Horsley Drive Business Park - Stage 2 (SSD 7664) - Notice of Exhibition

Thank you for your letter dated 12 December 2016, requesting Transport for NSW (TfNSW) review and comment on the above.

TAB A - Remaining Comments for the Horsley Drive Business Park - Stage 2 (SSD 7664)

Figure 10: Public & Active Transport Network

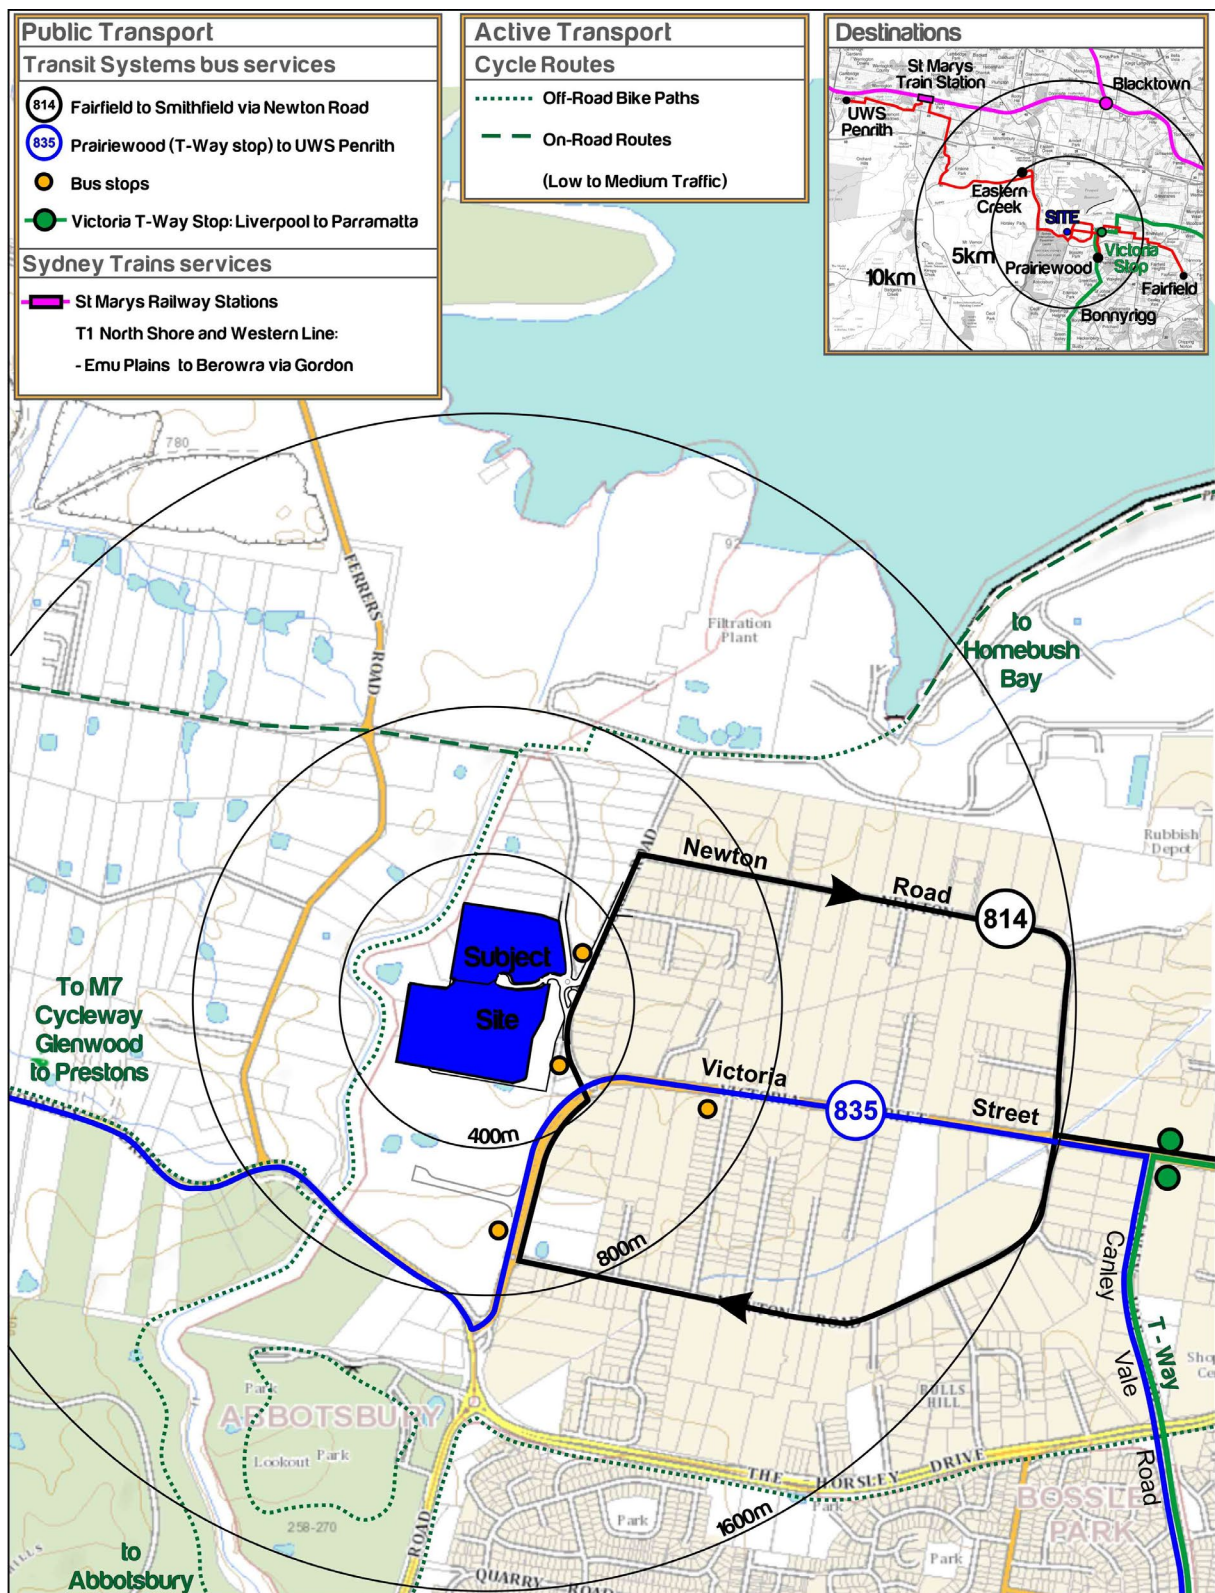
It is noted that the surrounding site has well provided cycle ways (as indicated on page 11 of the Traffic Report). The Traffic Report does not indicate whether the site will provide bicycle parking or end of trip facilities for active transport users to make use of the existing cycle way network adjacent to the proposed development.

Improvements to the foot path connections and cycle way links with regional transport network would have the potential to encourage active transport to the site.

TfNSW requests that the applicant provides bicycle parking or end of trip facilities in accordance with relevant guidelines and standards.

TfNSW requests that the applicant:

- Consider the provision of access footpaths from the shared path at the rear of the development leading to Lots one, two, three and four;
- Provide bike parking or secure bike parking for visitors and staff to the four lots and consider adding bike parking locations to the facilities shown in Figure 6 on the Traffic Report;
- Provide wayfinding signs advising the way to from the warehouse entrance to the shared path to the rear of the development;
- Consider the connectivity, safety and accessibility for pedestrians and bicycle riders to existing pedestrian and bicycle networks/road networks and public transport; and
- Develop wayfinding strategies and travel access guides, utilising resources from the Roads and Maritime Services website and Fairfield City Council website to assist with increasing the mode share of walking and cycling.
